**From:** Amanda Scholes on behalf of Planning.Responses  
**Sent:** 16 July 2020 10:16  
**To:** Planning Scanning  
**Subject:** FW: Details of Planning decision on Application Ref: LU/117/20/HH at 68 Armada Way

**Application No:** LU/117/20/HH  
**Site Address:** 68 Armada Way Littlehampton BN17 6QY  
**Grid Reference:** 504345 102458  
**Category:** Householder  
**Description of Works:** Two storey side and rear extension, and alterations to existing garage to form habitable accommodation.

PROPOSED REAR
(EAST) ELEVATION

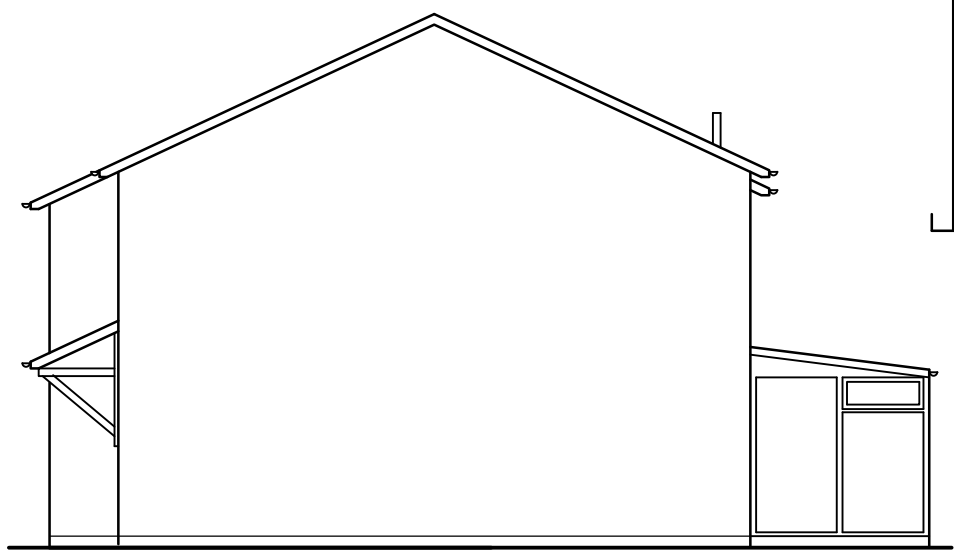
Non of my objections were looked into. How on earth can you tell me that the rear first floor window does not over look my garden. That the area behind my garage will not be effected by the wall of this huge extension.
